From: Adi [REDACTED]
Sent: 05 September 2019 11:18
To: Planning <Planning@arun.gov.uk>; Daun Johnson <Daun.Johnson@arun.gov.uk>
[REDACTED]
Subject: 21-23 Richmond Road, Bognor Regis - BR/248/19PL

In relation to the above site addresses planning application and following receipt of your attached letter, this email with the associated drawings has been prepared in response to the queries raised.

PROPOSED NORTH-WEST SIDE ELEVATION

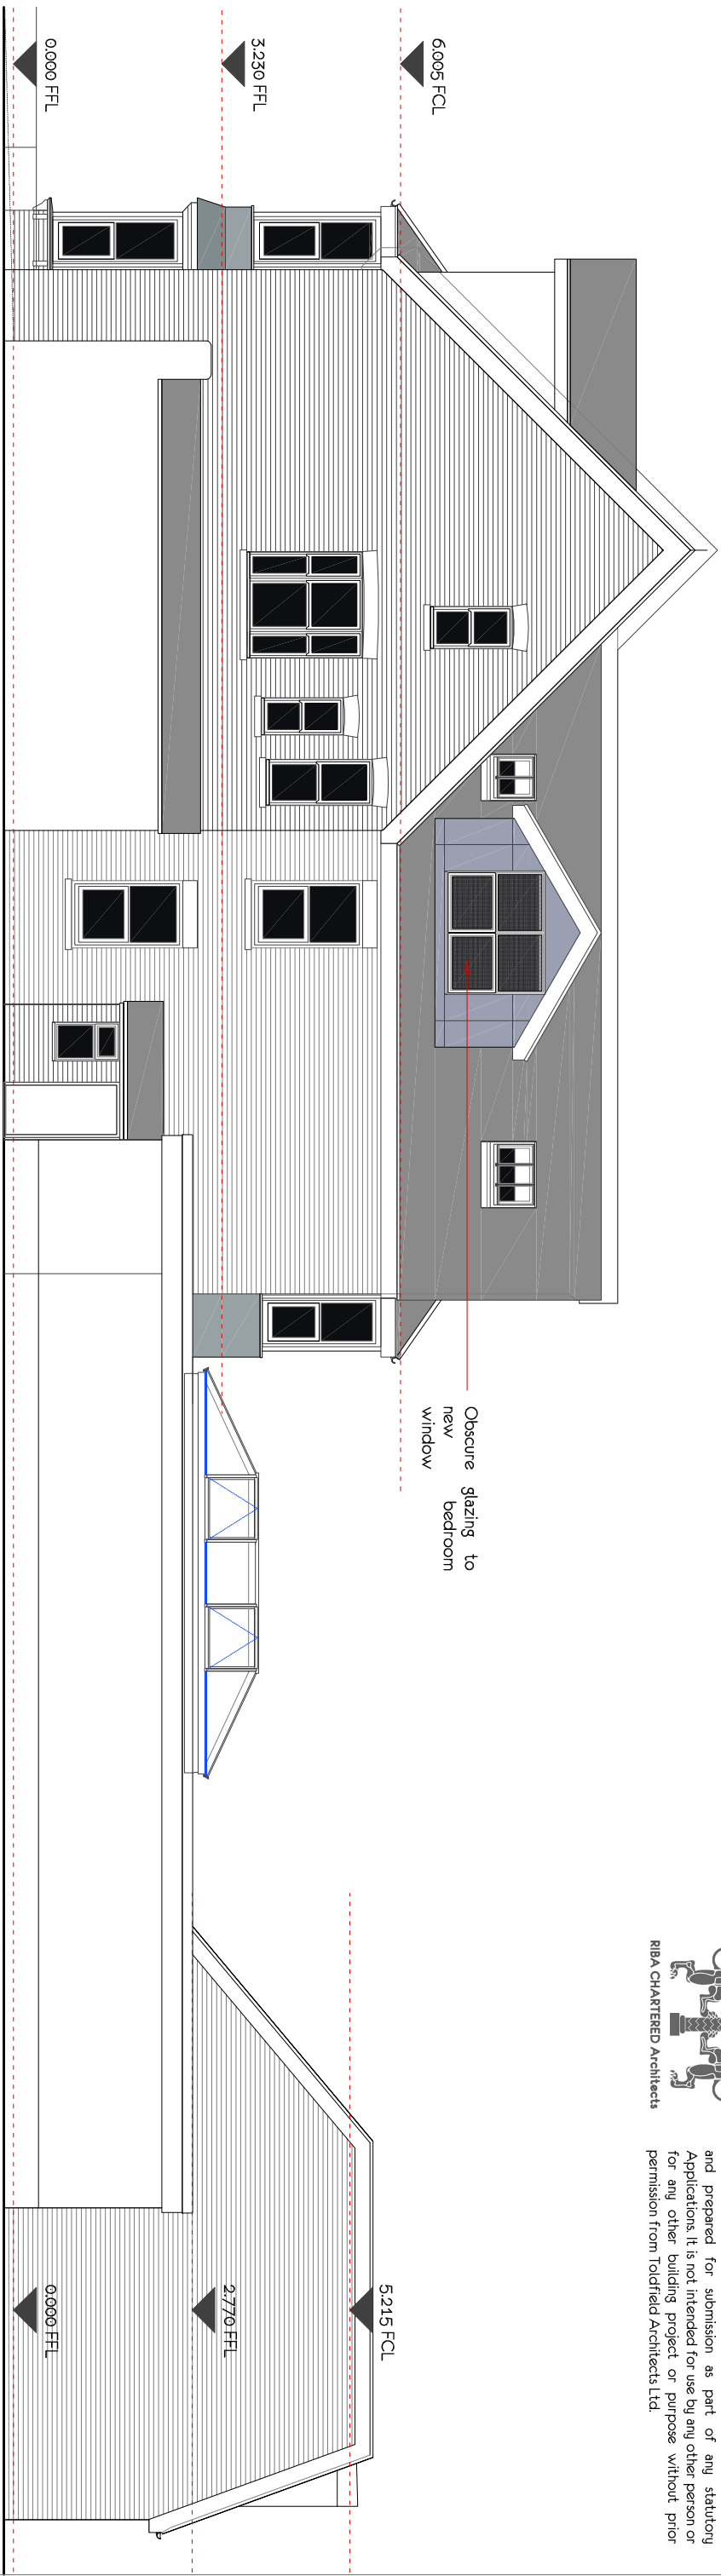
Finally regarding the comment associated with the Second Floor Plans and Side Elevations not matching, we have checked the drawings and aren't sure exactly what is being referred too, however we have checked and updated some parts of hatching within the elevations (Ref: attached Drawings P12, P13 & P15 Rev A).
